The Secretary,
An Bord Pleanála,
64 Marlborough Street,
Dublin 1

8th June 2022

Re: Case No. 313306 – Strategic Housing Development at Old Connell, Newbridge

Figure 2.2: Proposed Master Site Layout Plan. Source: O'Flynn Architects.

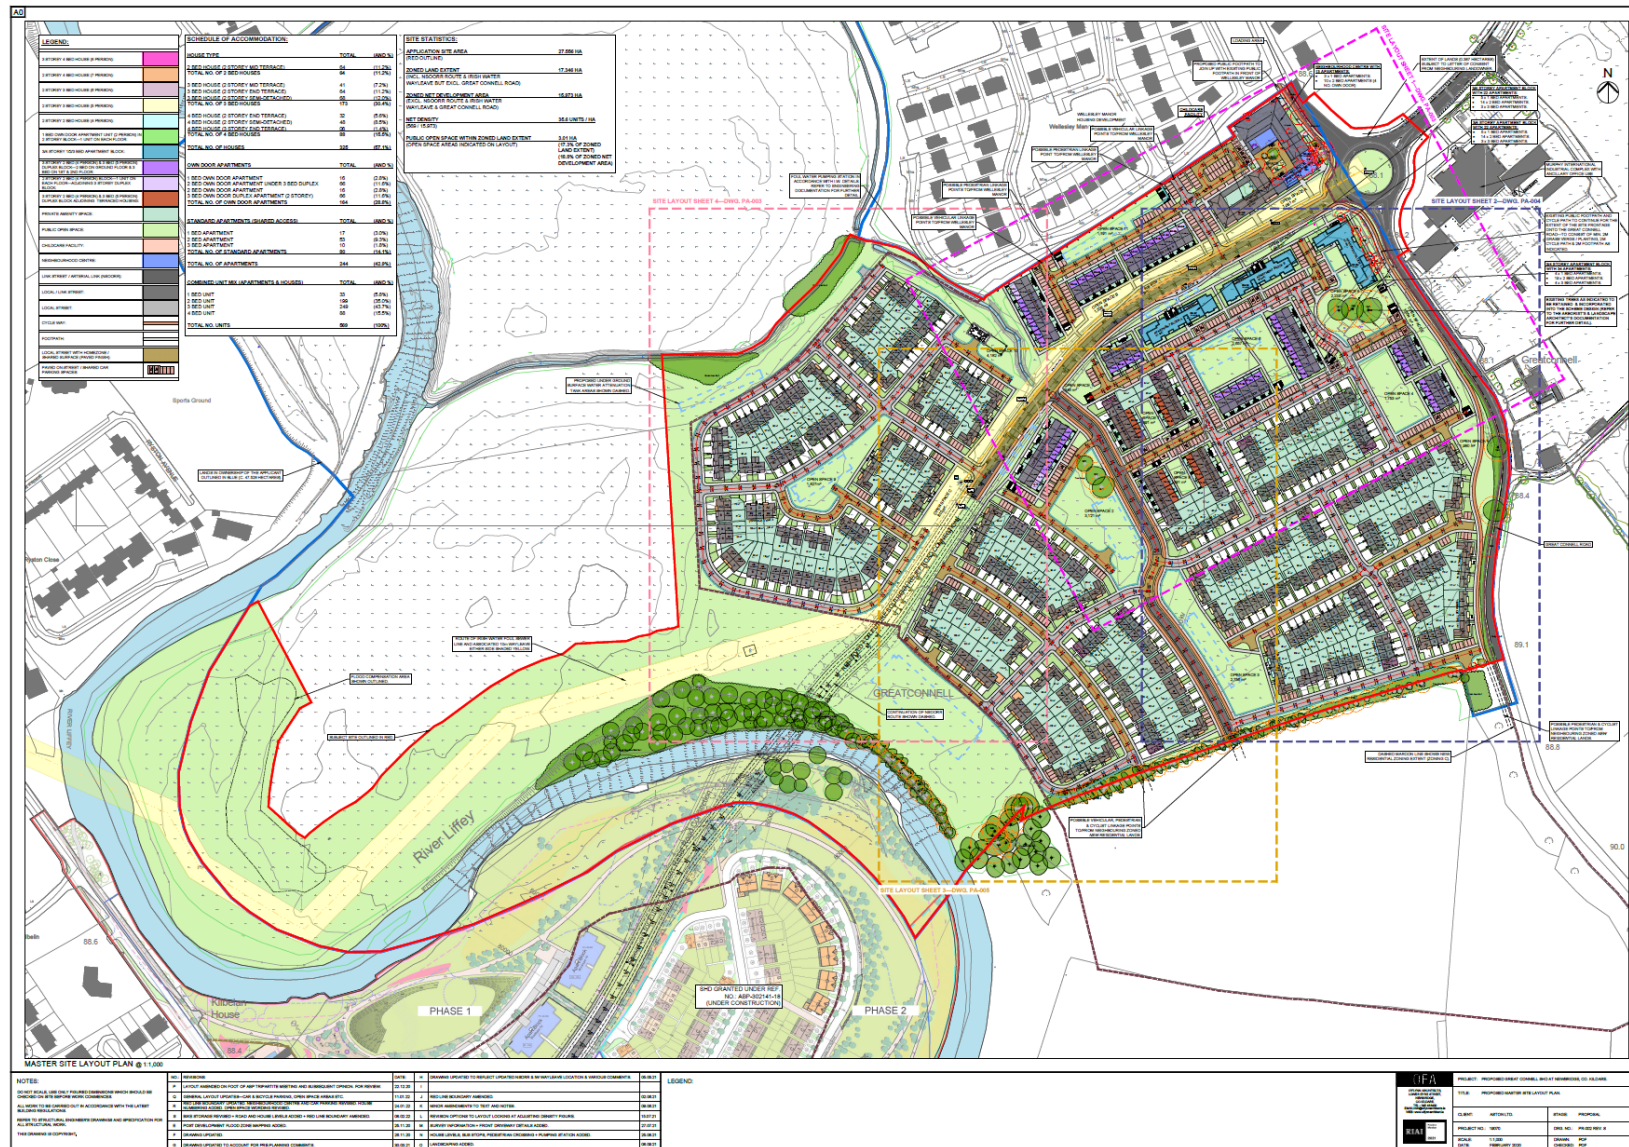
The Master Site Layout Plan includes bus stop designs whereby the cycle lane runs to the front of the bus stop, causing potential conflicts with cyclists and bus users. Best practice design is to run the cycle lane to the rear of the bus stop, thereby reducing the potential for conflict. The bus stops should also be in-line with the road.

Recommendation: It is recommended that the applicant is required to design the bus stops in accordance the *National Cycle Manual* guidance and best practice design in which the cycle lane travels behind the bus stop in order to minimise potential conflict and that the bus stops are kept in-line with the road.

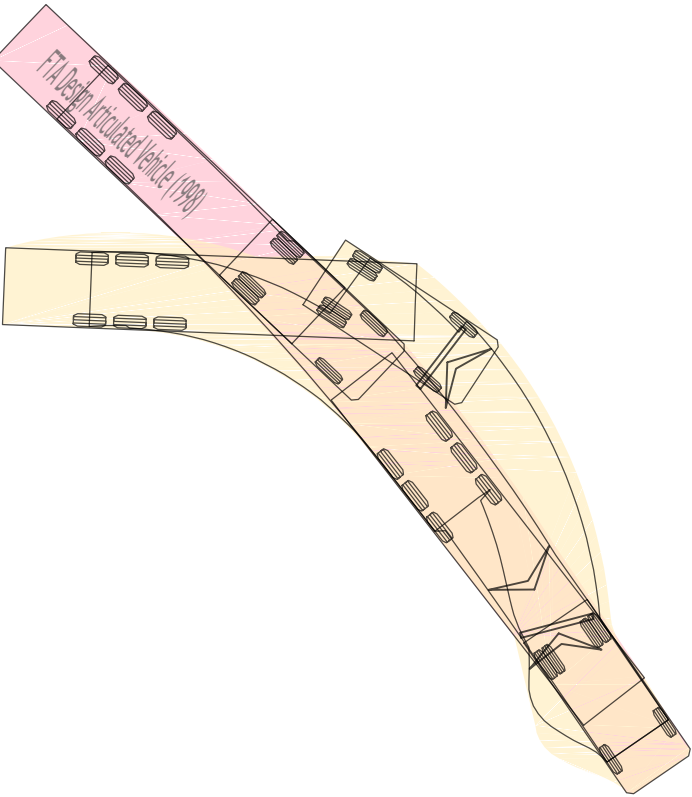
The proposed signalised junction with the Great Connell Road will be an important junction for pedestrian, cyclist and potential public transport users. The proposed cycle track on the NSORR will connect across the junction to the adjacent employment uses and forms part of the GDA Cycle Network Plan as a proposed secondary cycle route for Newbridge. The NTA welcomes the upgrade of the junction to a signalised junction, however, given the importance of the route, it is recommended that the junction should be a protected style junction in accordance with the *Preliminary Design Guidance Booklet for BusConnects Core Bus Corridors* and the upcoming revised *National Cycle Manual*.

Recommendation: In the interests of providing a safe and efficient junction at this location on a secondary route in the GDA Cycle Network, it is recommended that a protected style junction is provided in accordance with the *Preliminary Design Guidance Booklet for BusConnects Core Bus Corridors* and the upcoming revised *National Cycle Manual*.
